From: Anita Gardner <Anita.Gardner@arun.gov.uk>
Sent: 16 August 2021 10:02
To: Planning.Responses <Planning.Responses@arun.gov.uk>
Subject: FW: 27 Central Drive M/91/21/PL

From: g raven [REDACTED]
Sent: 30 July 2021 11:07
To: Anita Gardner <Anita.Gardner@arun.gov.uk>
Cc: Jacky Pendleton [REDACTED]
Subject: 27 Central Drive M/91/21/PL

May I draw your attention to two very significant items in the Design Statement which formed part of the documentation submitted with the original planning application M/25/19. The first, under "Principles" states " 1. To be in context and respect the existing residential area character. 2. To minimise any impact on adjoining properties." The second, under "Scale" states " The scale of the house is in keeping with its near neighbours in both height and massing".

PROJECT	27 Central Drive - Elmer Beach	DATE	16/09/18
TITLE	Proposed South Elevation	DRG NO	IBA/507/05
SCALE	1 : 50	REVISIONS	B

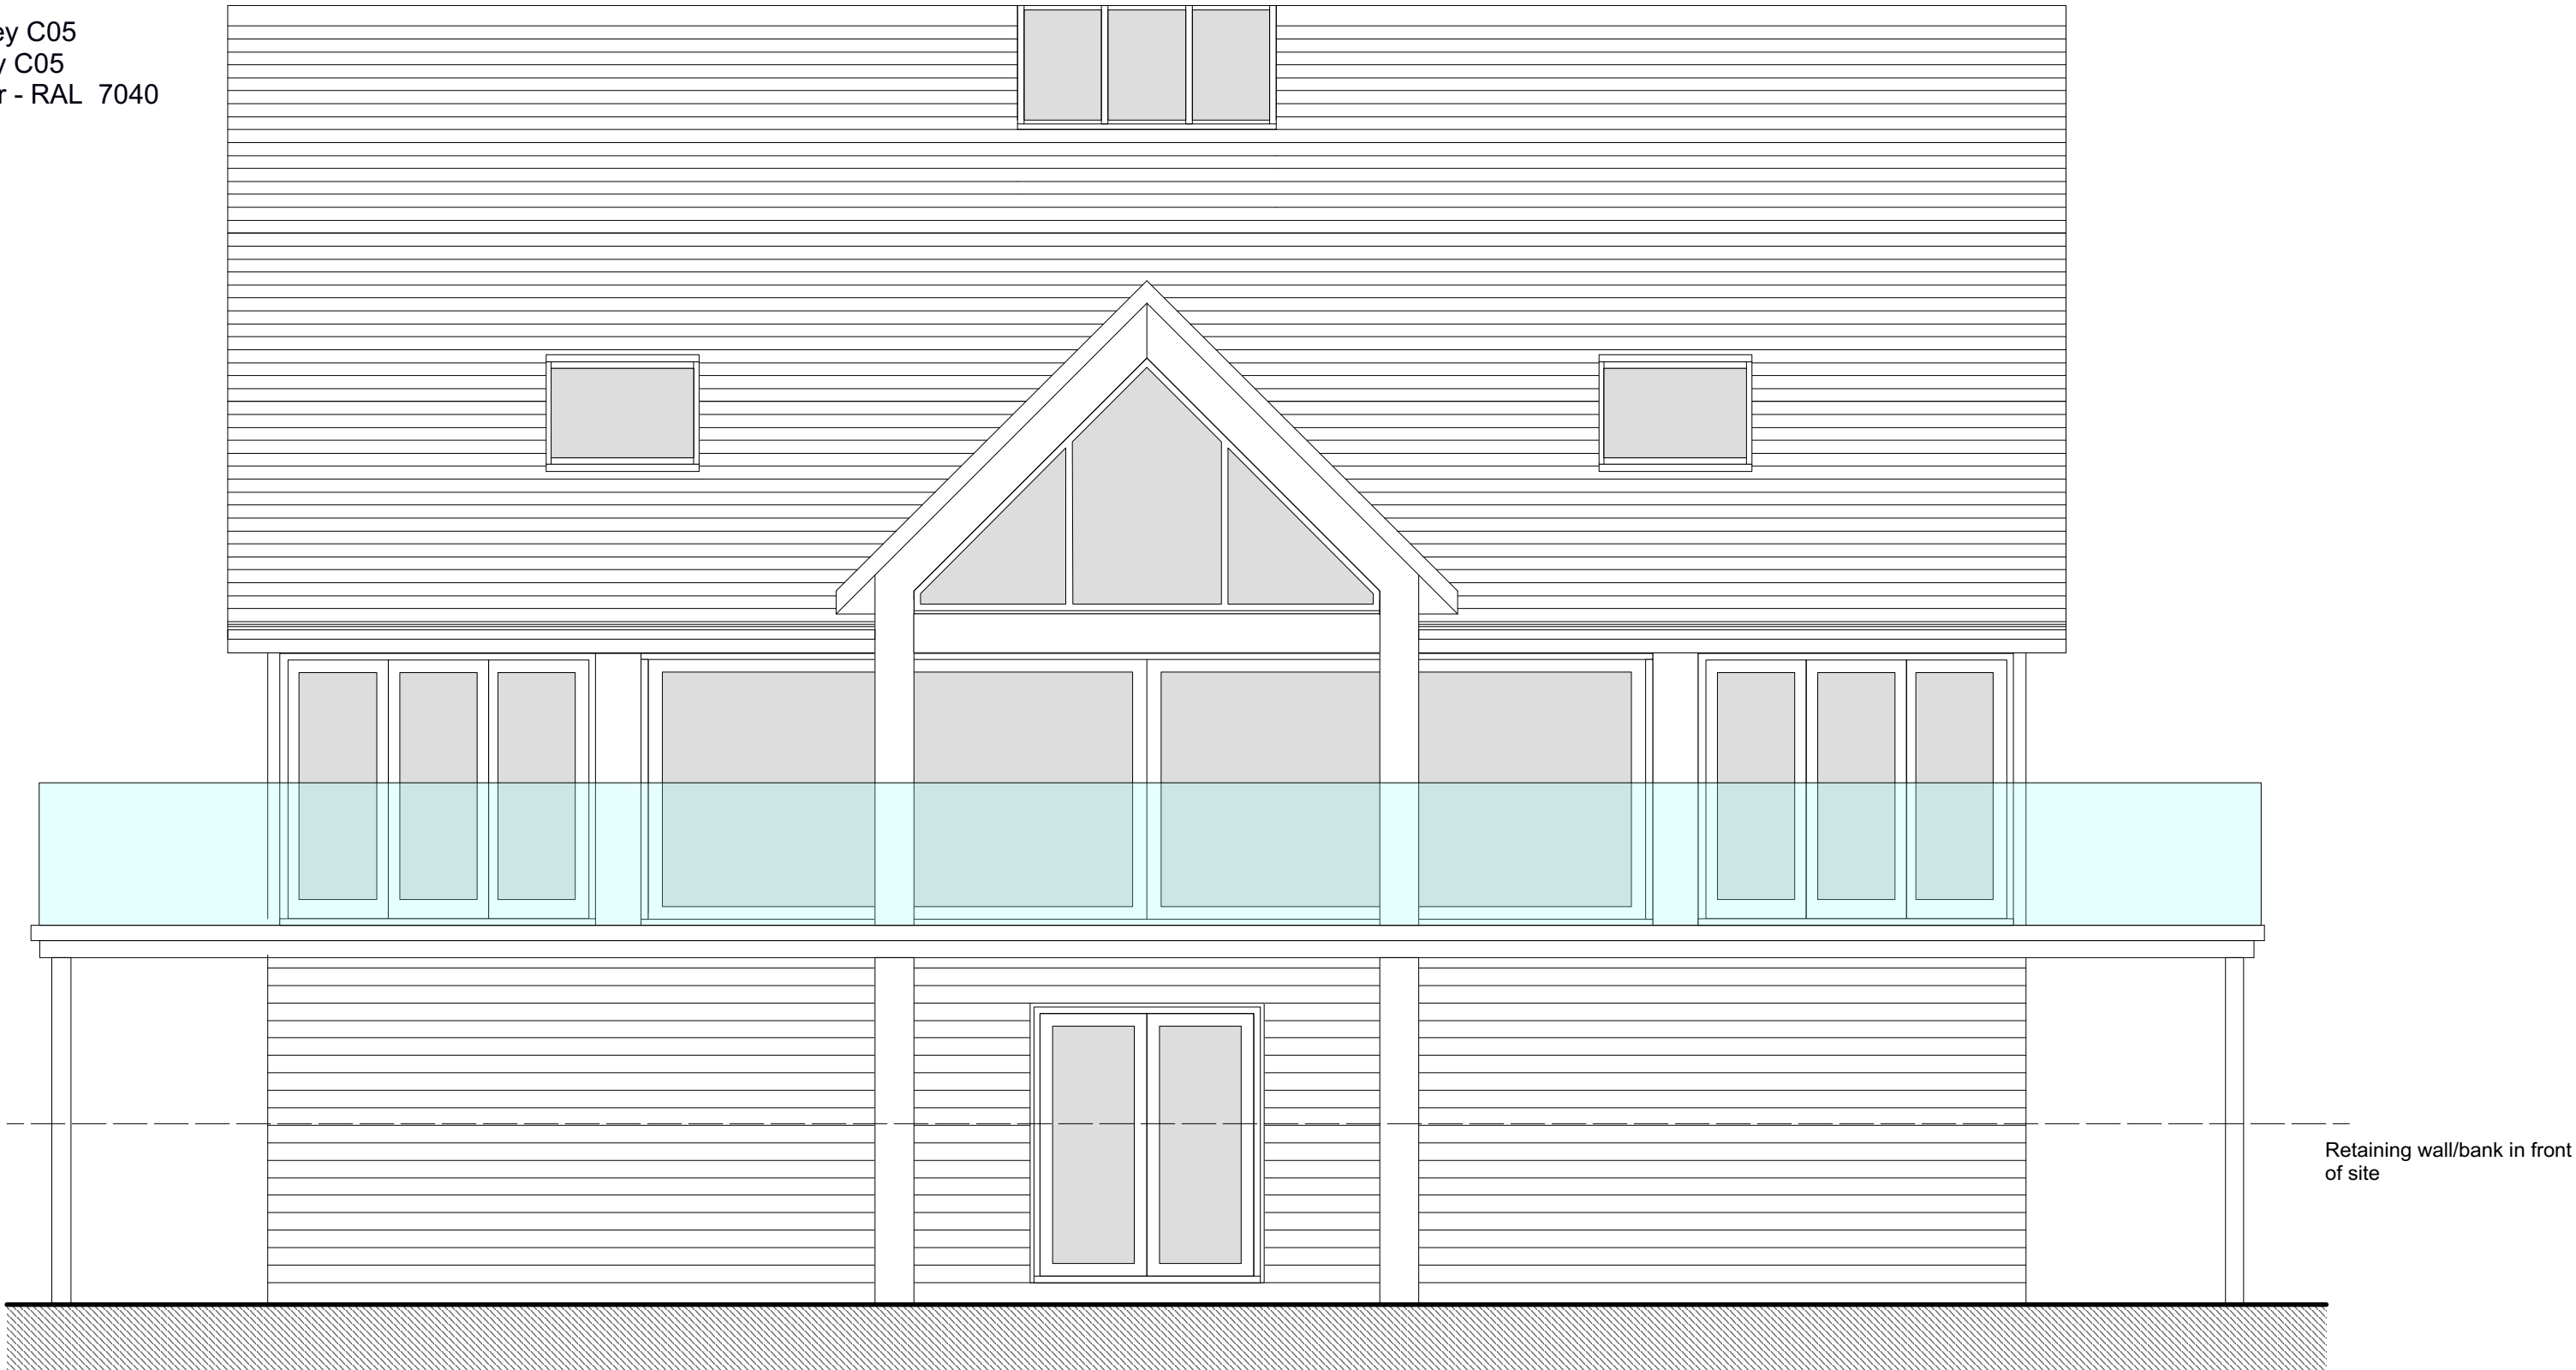
The apparent intention thus stated is entirely in keeping with the drawings which show the new house as approximately level with next door. It is only at odds with the building as constructed.

The builders consistently claim that the height is entirely as approved. I do not know exactly what is meant by this since as far as I can see the approval does not specify the height in figures merely stating that the building must be constructed in accordance with the plans.

It seems to be the case that what was actually approved was a representation of, among other things, the height. If the builders' claim is true, that representation was inaccurate and misleading and should invalidate the approval. I do wonder whether, somewhere along the line, it is the scale which is either wrong or has been wrongly applied in scaling up from the drawings, and if so does this mean that not only the height but other dimensions are oversize.
